West Burton Solar Project

Schedule of Changes (Deadline 1)

PINS reference: EN010132
Document reference: EX1/WB8.1.8
The Infrastructure Planning (Examination Procedure) Rules 2010
Rule 8(1)(k)

### Figure 8.18.1: Landscape and Ecology Mitigation and Enhancement Measures West Burton 1

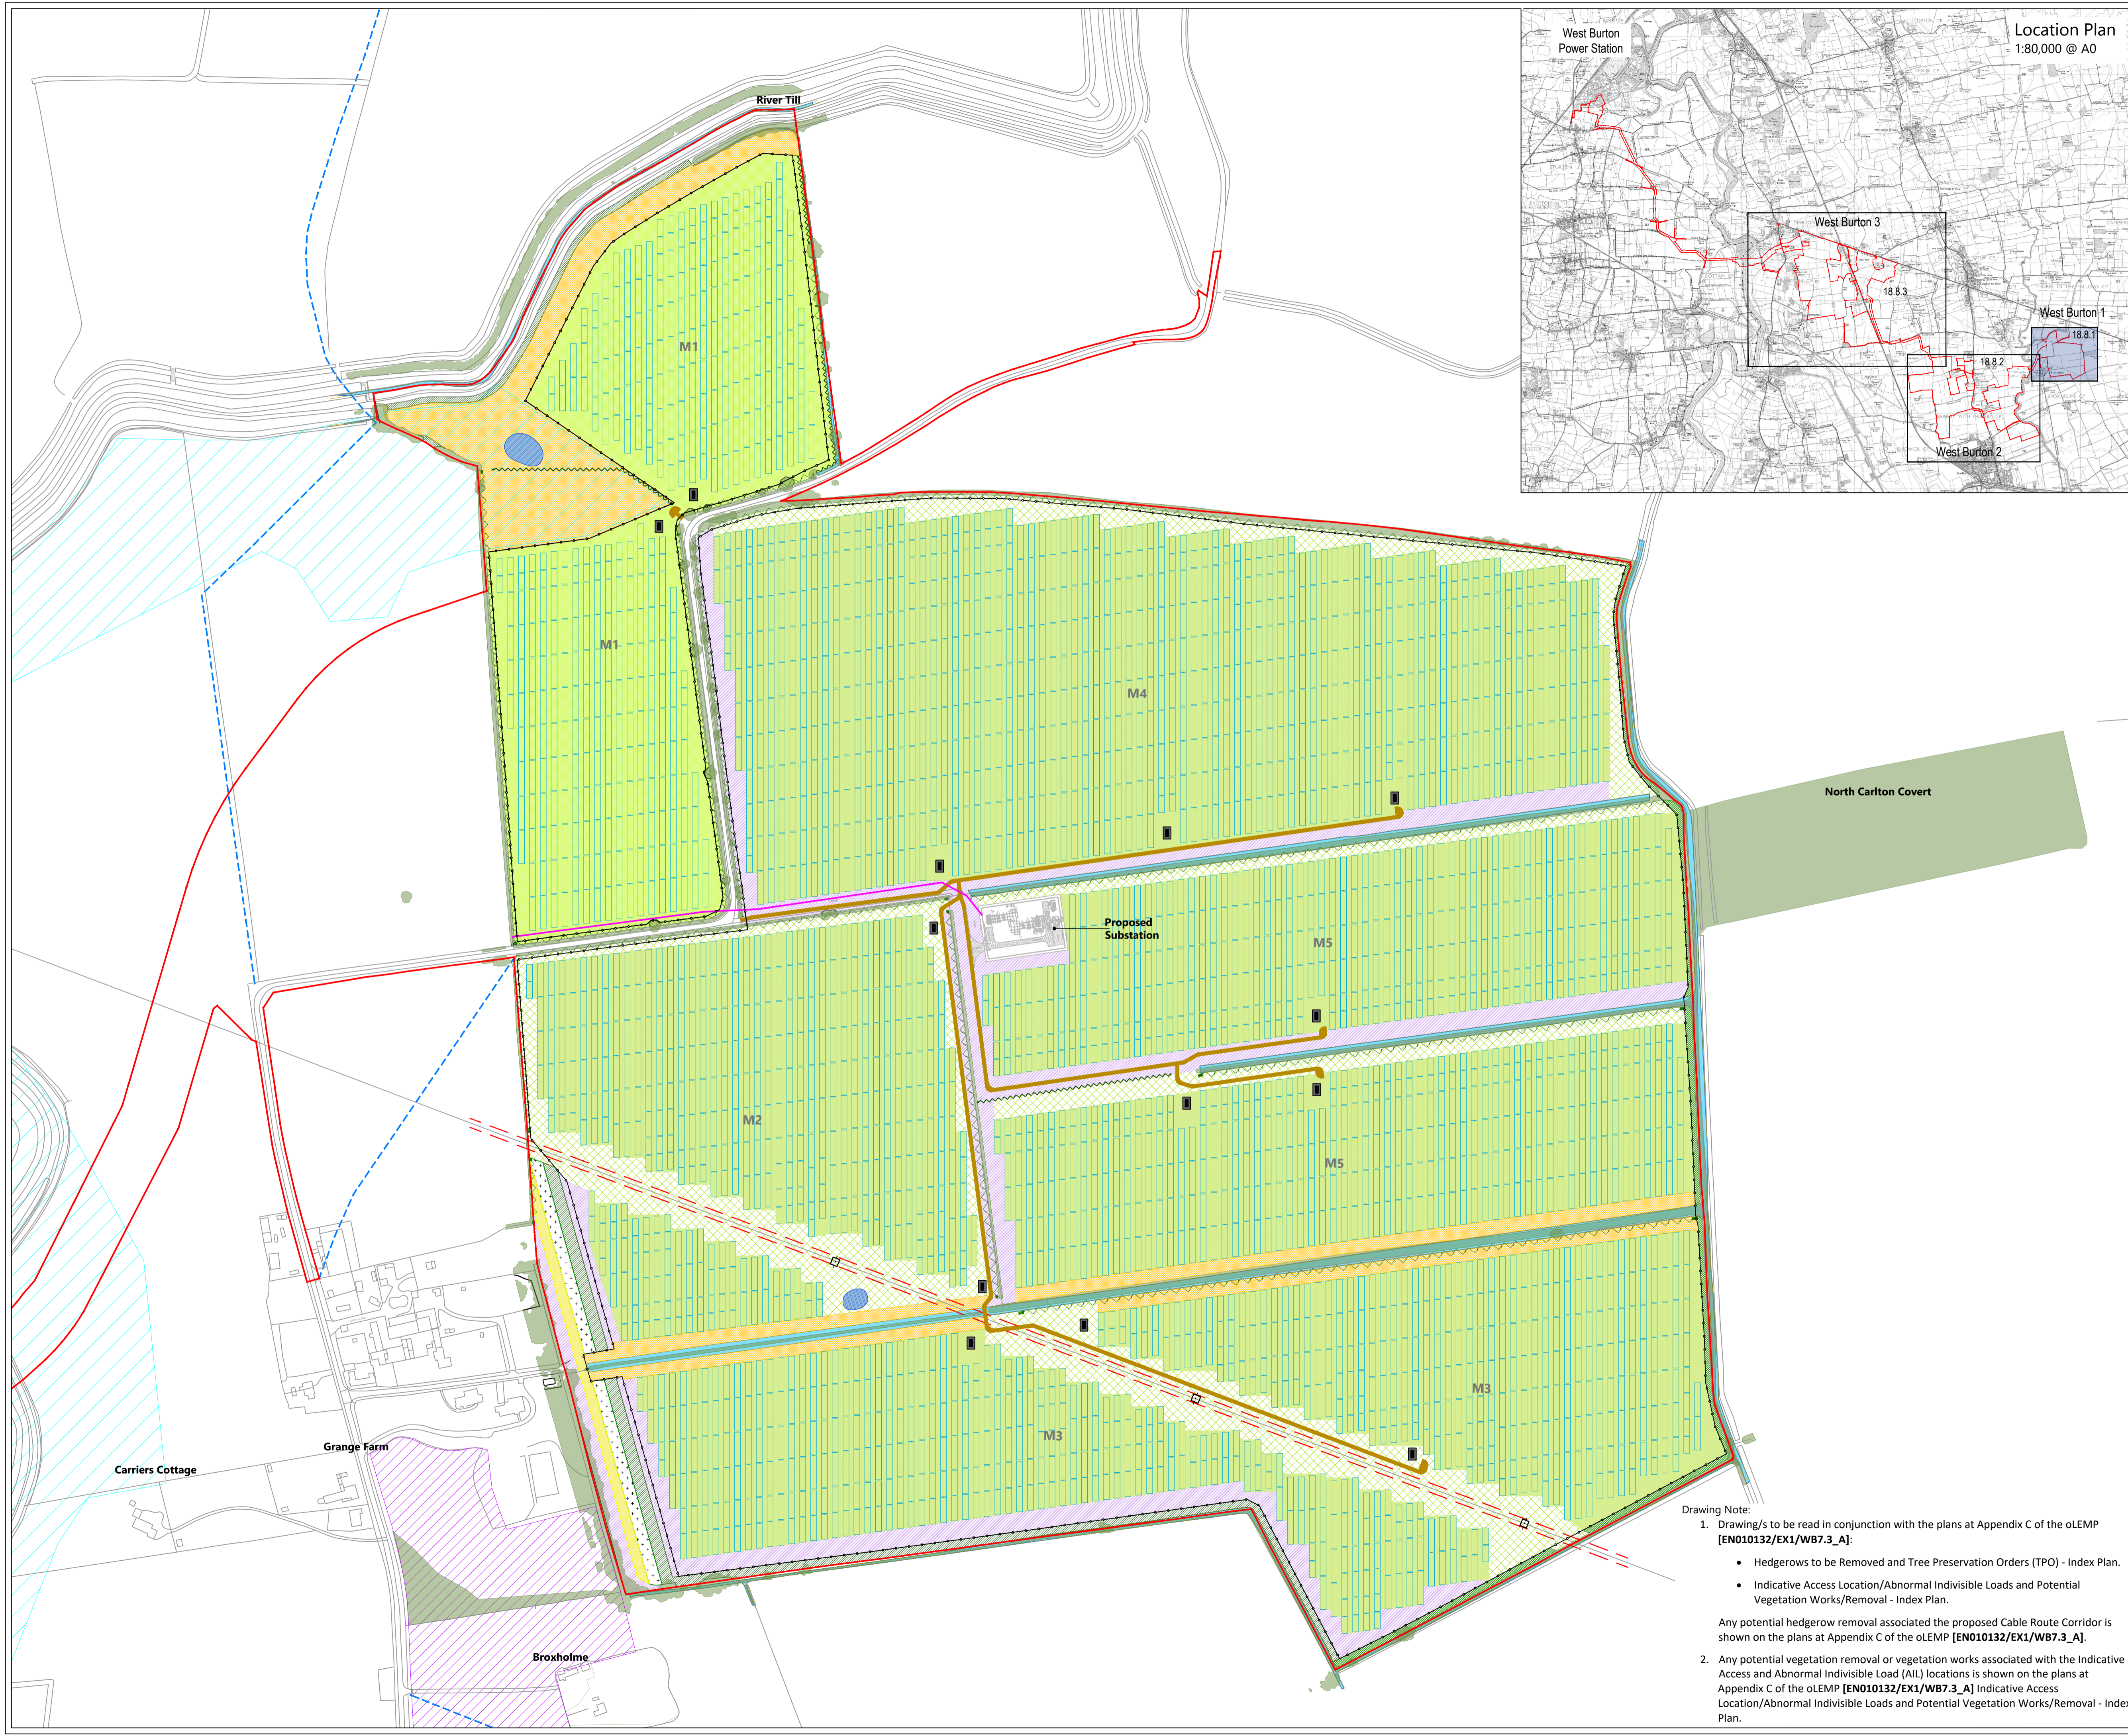
Document Name	Submitted Document Reference	Revision and New Reference	Change	Reason for Change
Measures - West Burton 1				
WB6.4.8.18.2 ES Figure 8.18.2 - Landscape and Ecology Mitigation and Enhancement Measures - West Burton 2	[APP-282]	Revision A [EX1/WB6.4.8.18.2_A]	Correction of typos, to show additional hedgerows to be removed and to provide clarity of IDB Drain locations.	Minor editorial changes for clarity.
WB6.4.8.18.3 ES Figure 8.18.3 - Landscape and Ecology Mitigation and Enhancement Measures - West Burton 3	[APP-283]	Revision A [EX1/WB6.4.8.18.3_A]	Correction of typos, to show additional hedgerows to be removed and to provide clarity of IDB Drain locations.	Minor editorial changes for clarity.
WB6.5 Environmental Statement - Non-Technical Summary	[APP-308]	Revision A [EX1/WB6.5_A]	Paragraphs 6.3.60 to 6.3.62 corrected to show that the significant effects are adverse.	To correct typographical errors.
